Project Name: Richardson Lot Line Adjustment

Project Number: VR 18 1

Description: Approval is being requested to adjust the common lot lines of Lot 12 and 13 of Sage Creek South 3 to bring into compliance the setback of an existing building. These lots are located west of Murr Road and south of Falcon Highway in Section 13, Township 13 South, Range 64 West, El Paso County.

AS PLATTED

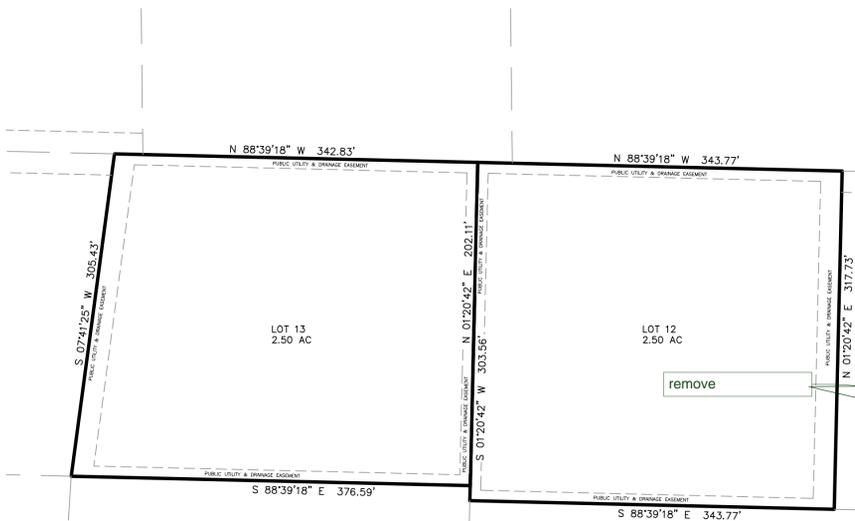
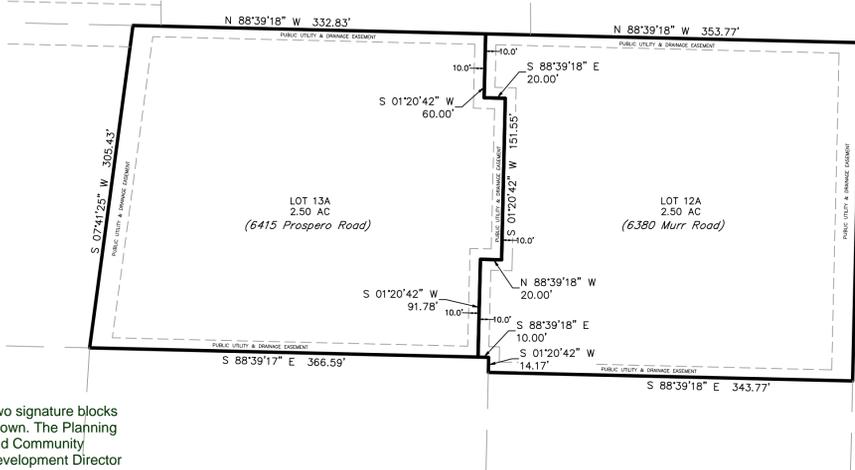
The measurements on the survey provided do not add up between the Platted and Replatted drawings. Until MVEA can review drawings with the correct dimensions and with the underground electric facilities located and shown on the replat we cannot provide comments.

There are existing MVEA electric facilities within these parcels protected with platted easements. If there is any removal or relocation of facilities it will be at the expense of the applicant and a review of easements will be required in order to proceed.
